**Former Volkswagen Van Centre, Comet Way, Hatfield, AL10 9TF**

**Submission of details pursuant of condition 8 (piling) on planning permission 6/2020/3222/maj.**

After a review of the submitted information, we **do not recommend** the discharge of Condition 8 (Piling) at this time.

BY:	Author	DRAWING TITLE:	PILE SETTING OUT GA
CHKD:	Checker	SCALE @ A0:	As indicated
DATE:	Jul22	DRAWING STATUS:	CONSTRUCTION
Rev:	C1

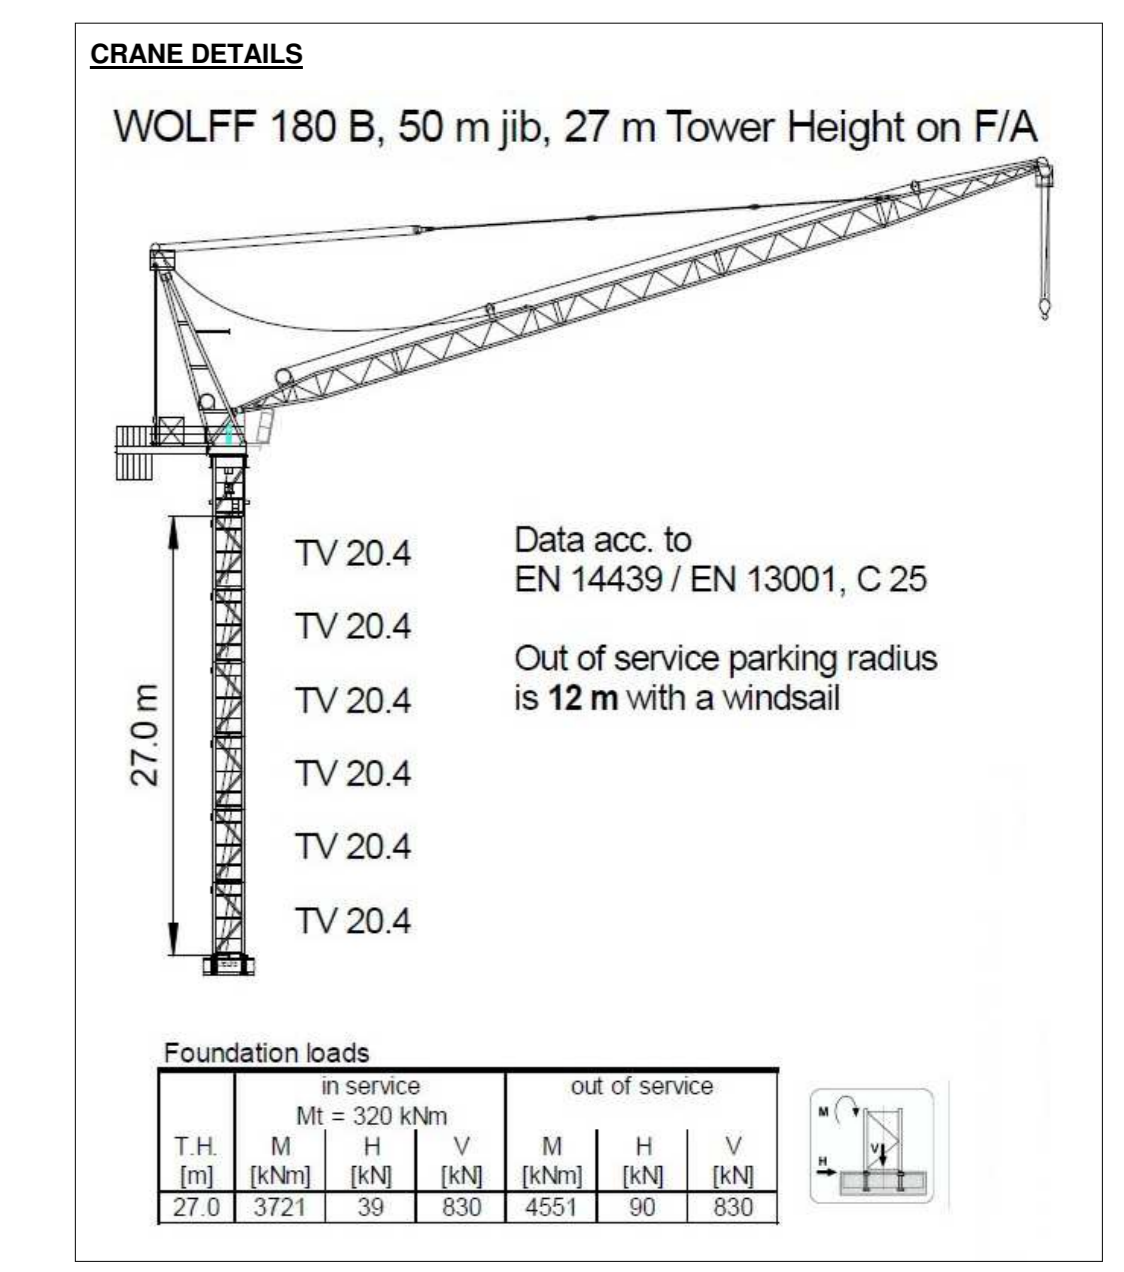
The submitted information does not answer the question of whether or not the piling works pose a risk of exacerbating the existing groundwater pollution.

The applicant will need to submit further information showing that risks of exacerbating the existing groundwater pollution through piling have been identified and addressed.
